**From:** Brenda Larsen  
**Sent:** Monday, July 22, 2013 2:09 PM  
**To:** Jeff Watson  
**Subject:** RE: BL-13-00012 Buress

Re: Buress (BL-13-00012)

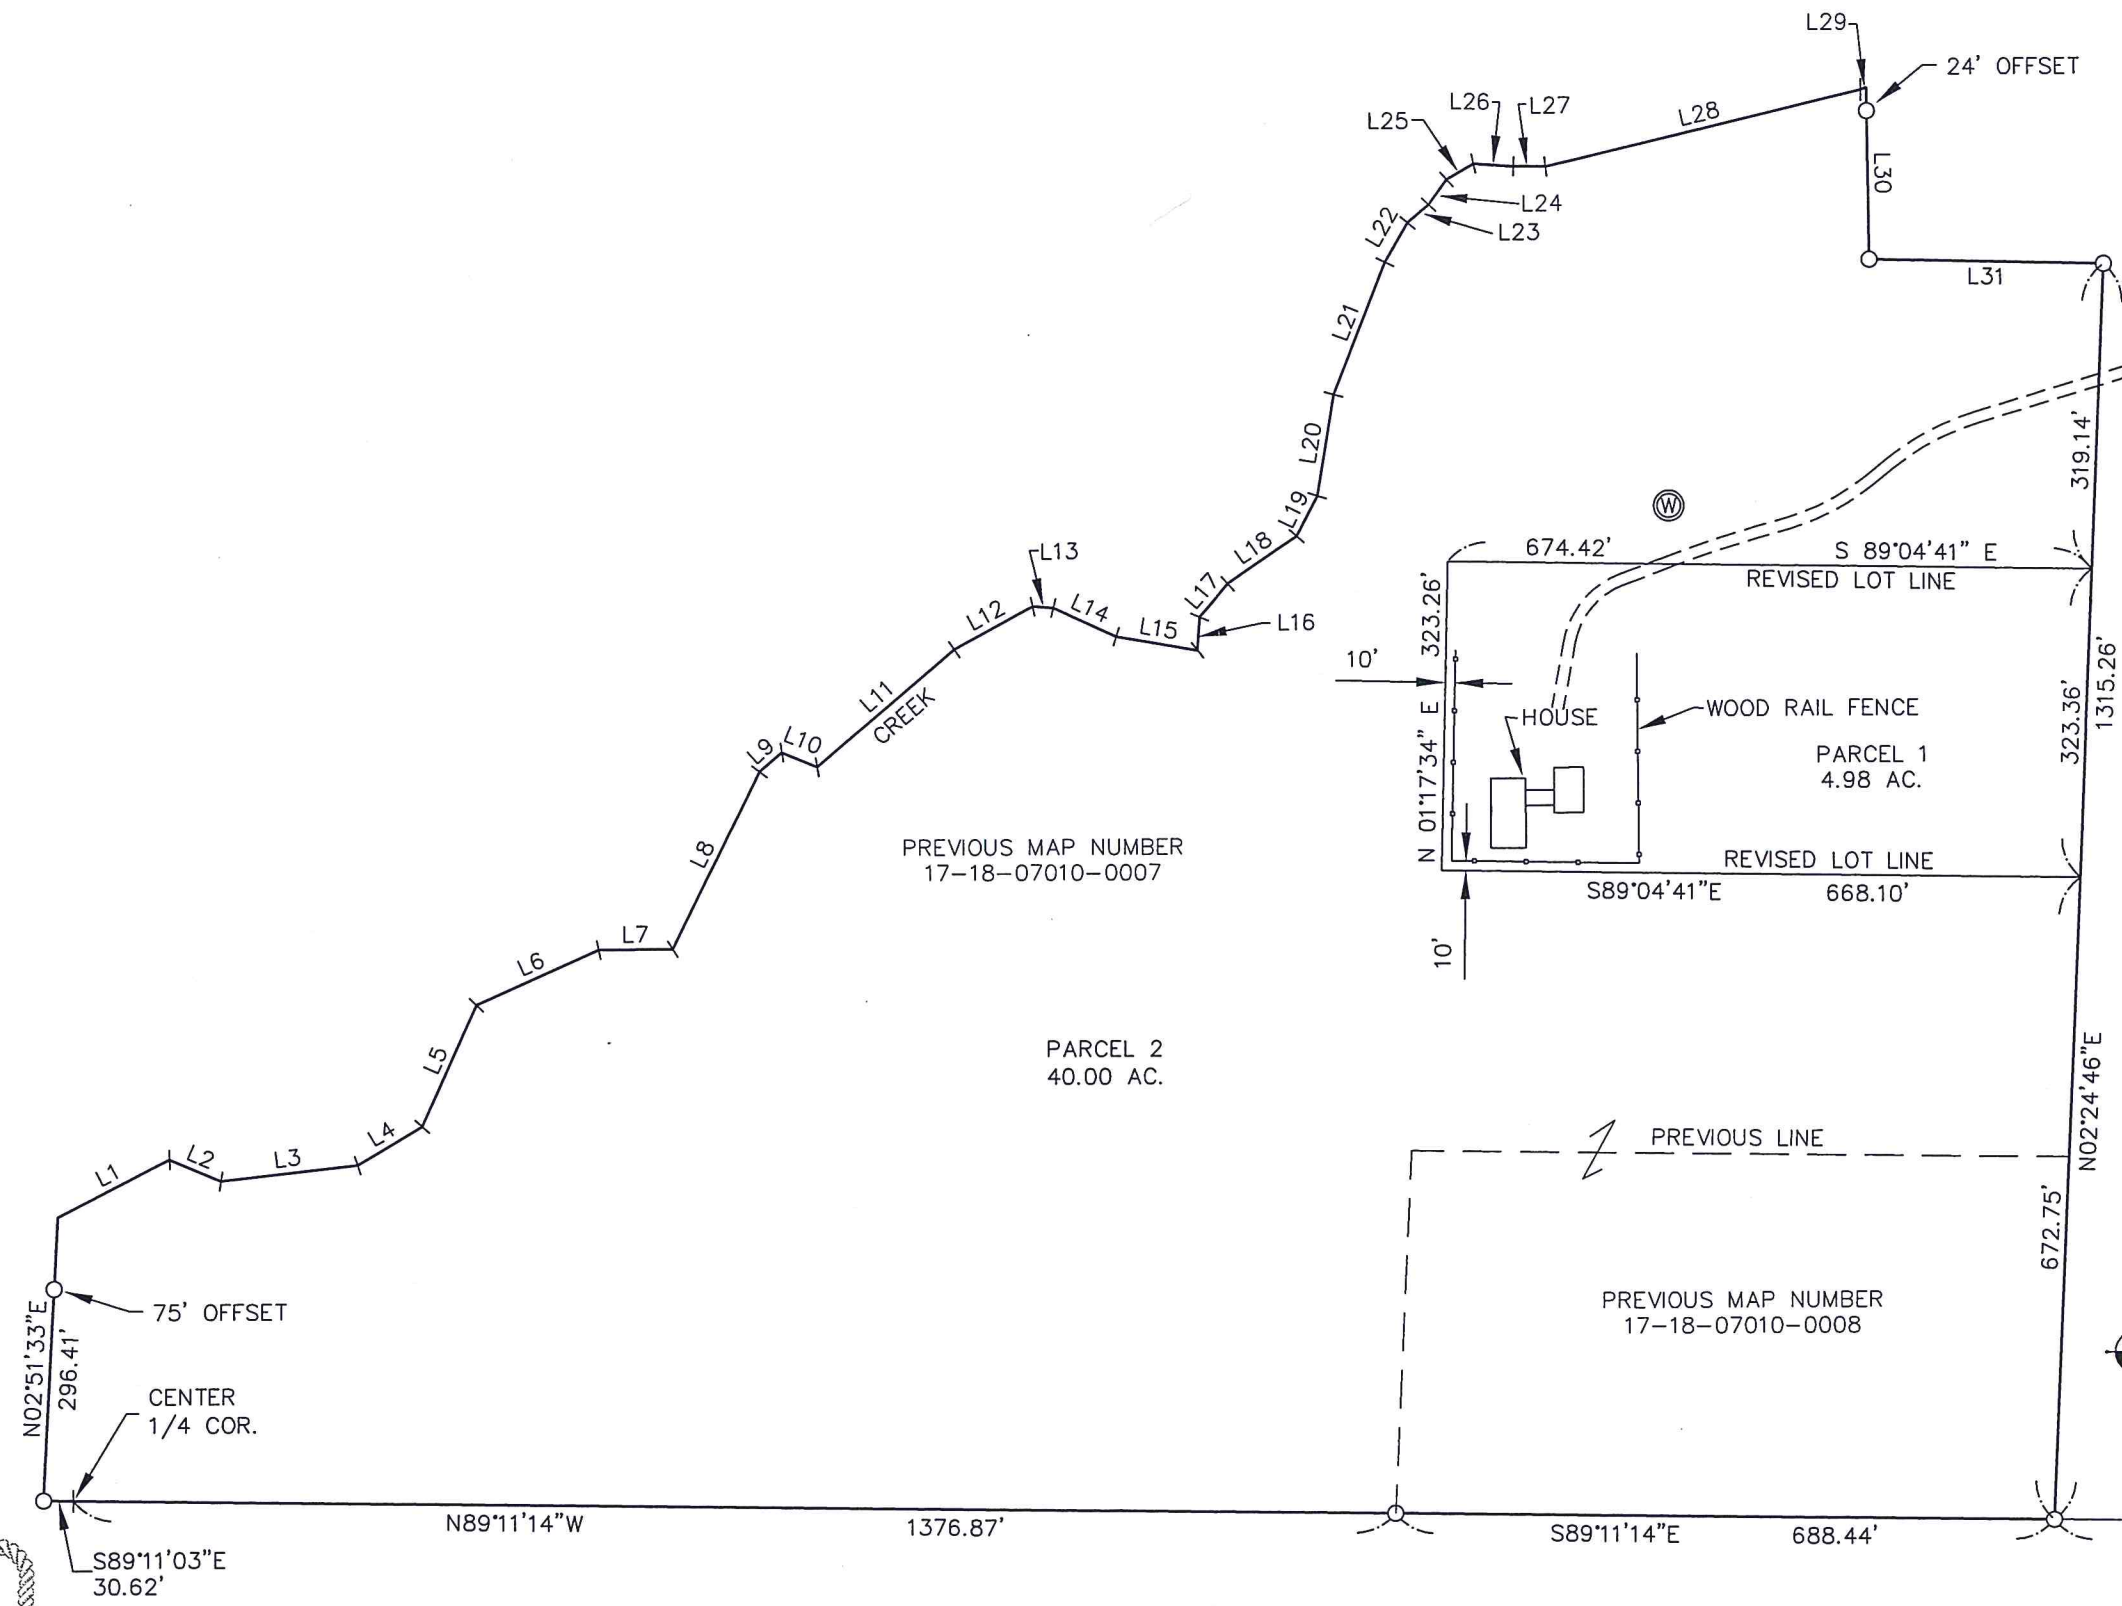
- Ensure that boundary line adjustments do not infringe upon existing structures, to include propane tanks, etc.
- Ensure adequate access for fire apparatus. Any driveways or access points created based off the new lot configurations shall comply with Kittitas County Code 20.02.030.
- All future development must comply with the International Fire Code.
